KITTITAS COUNTY COMMUNITY DEVELOPMENT SERVICES

August 21, 2020

Subject: Hein Preliminary Shore Plat (SP-20-00004) – Transmittal of Comments and Request for Additional Information

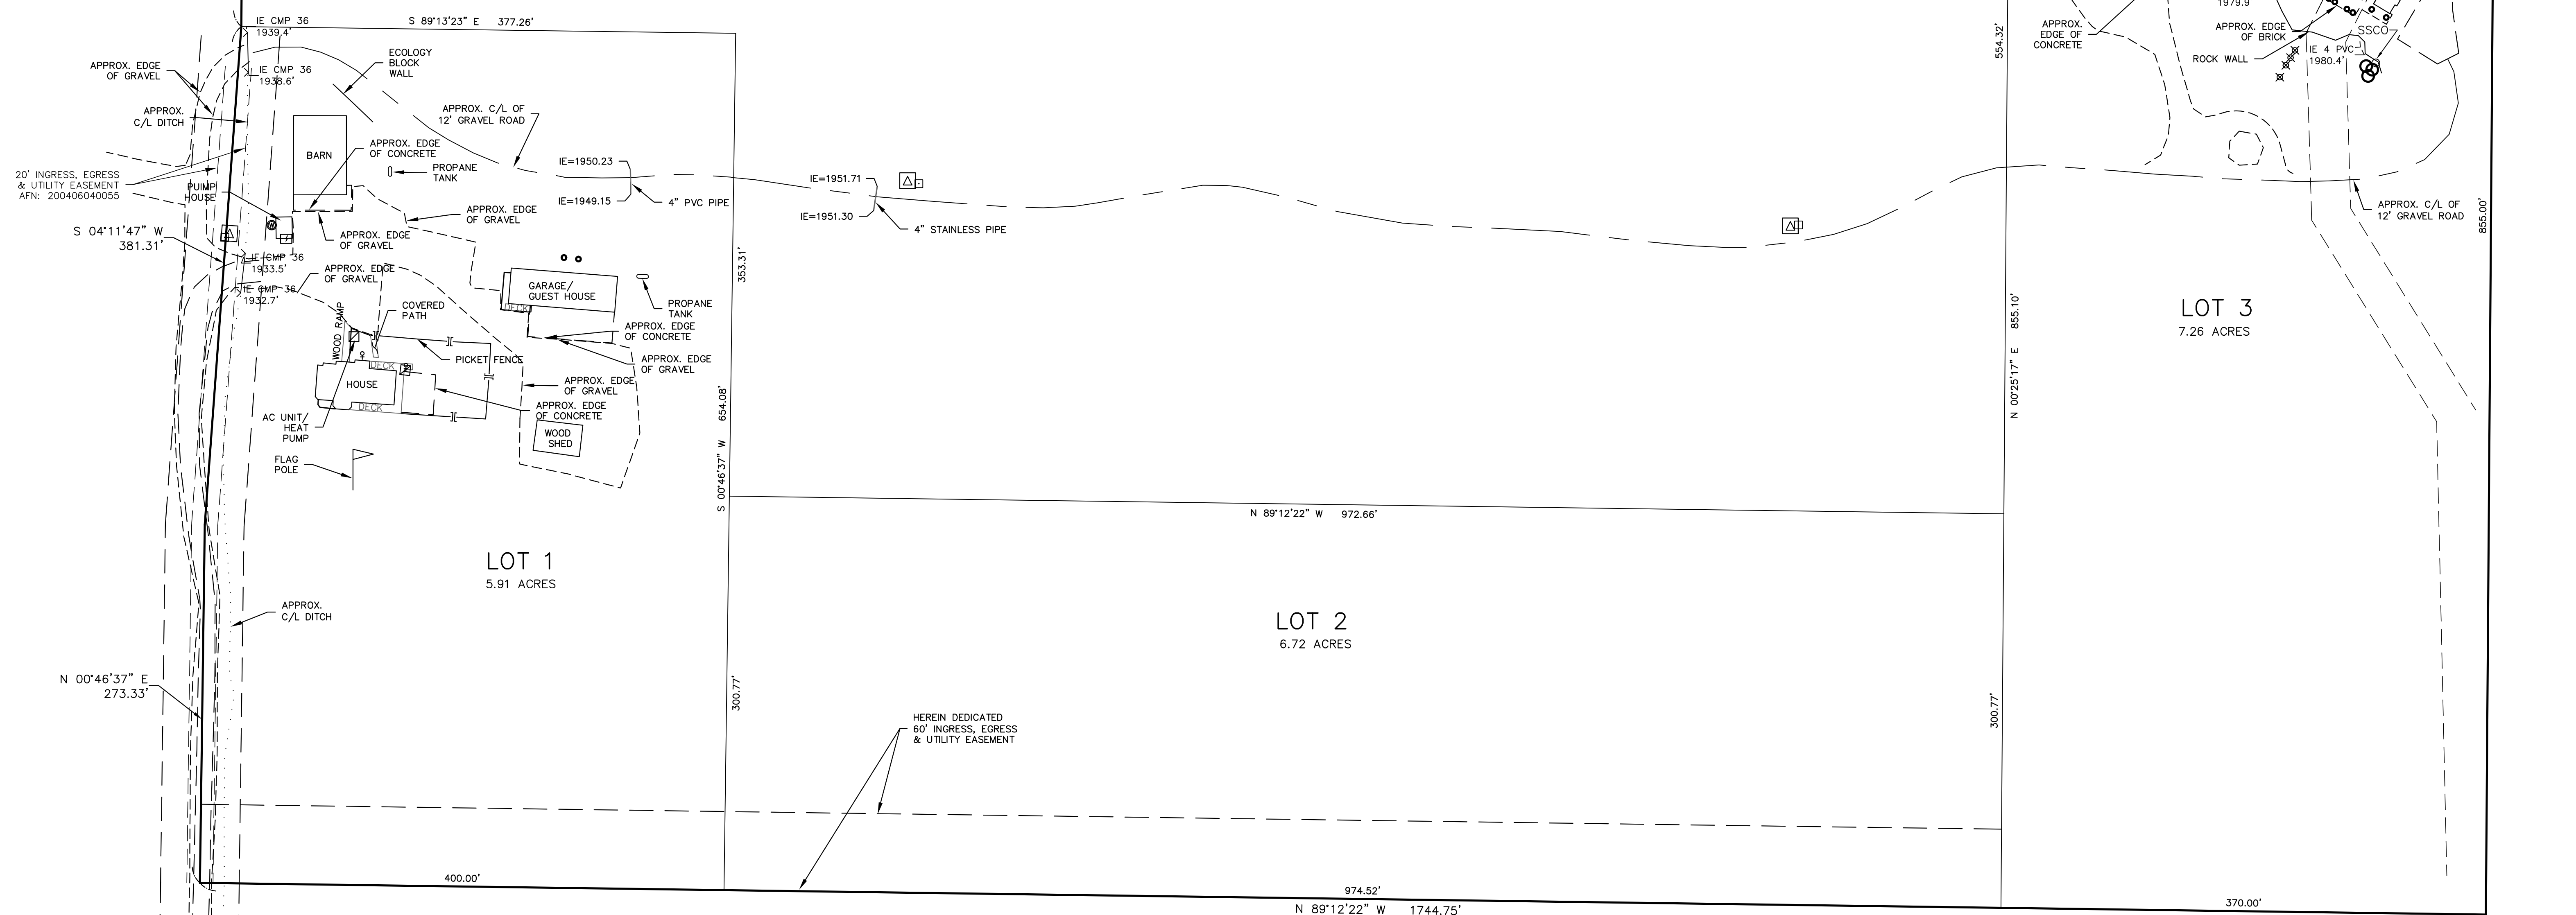
The north property line for lot 3 needs to be relocated to be at least 50 feet from the existing well.

8. Easement Correction: The 30' access & utility easement crossing Lot 3 must be amended so the home does not encroach upon the easement.

AIRPORT ROAD SHORT PLAT APPLICATION

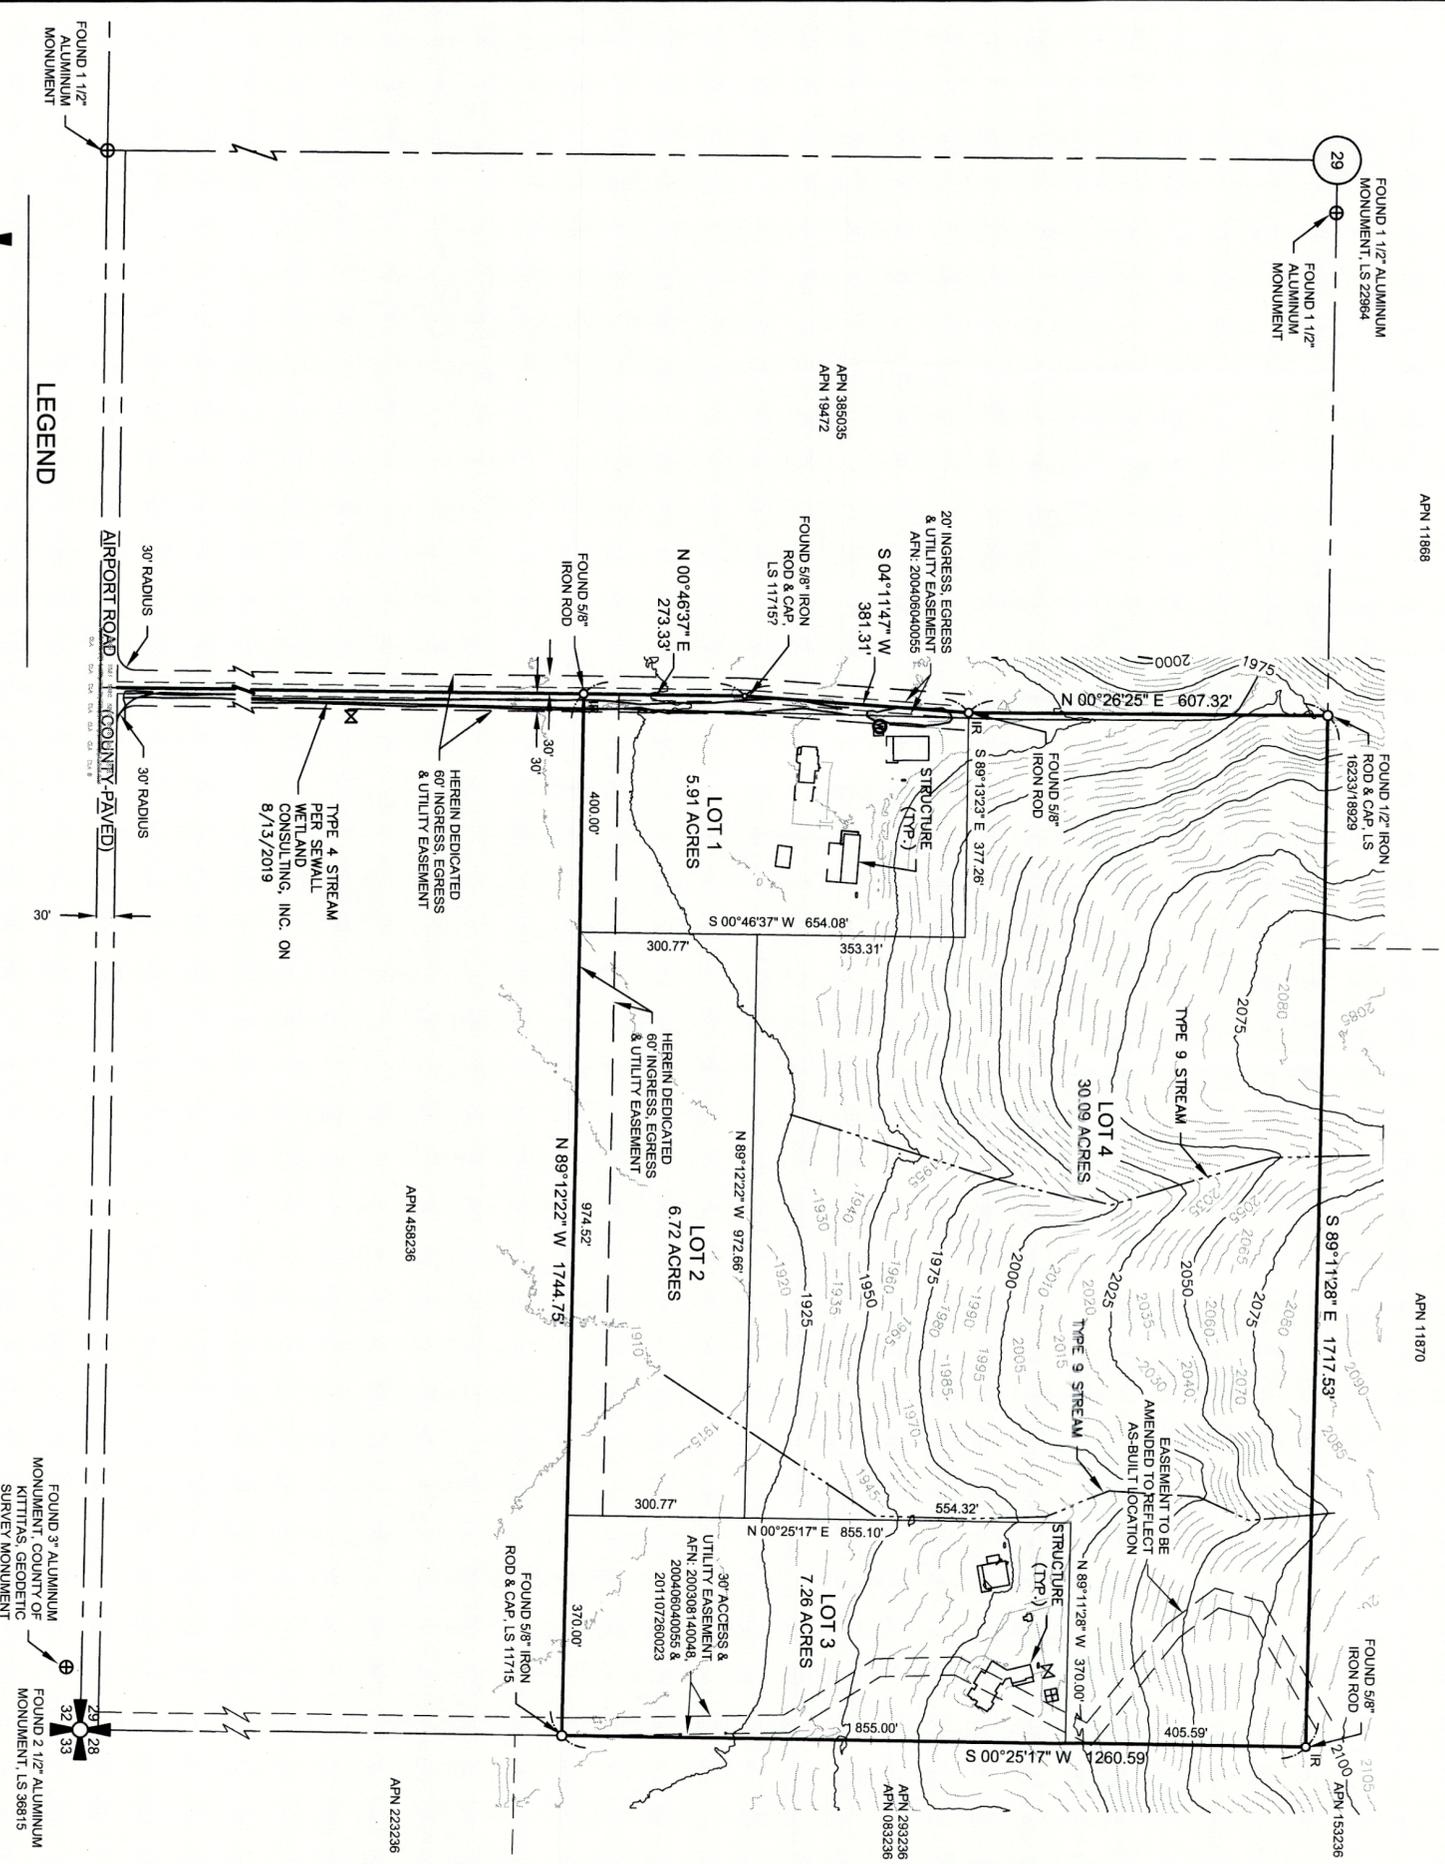
B-2 13.35.020(b) requires proof of adequate water supply, which can be submitted through a well log or 4 hour draw test result. If shared wells are used, a signed, notarized, and recorded shared well-users agreement must be submitted. All individual and shared wells must meet the distance requirement of 50 feet from the property line, 50 feet from the septic tank and 100 feet from the drain field as per Kittitas County Critical Areas Ordinance 17A.08.25, and KCC Chapter 13. Locations of wells on lots 1 and 3 must be provided.
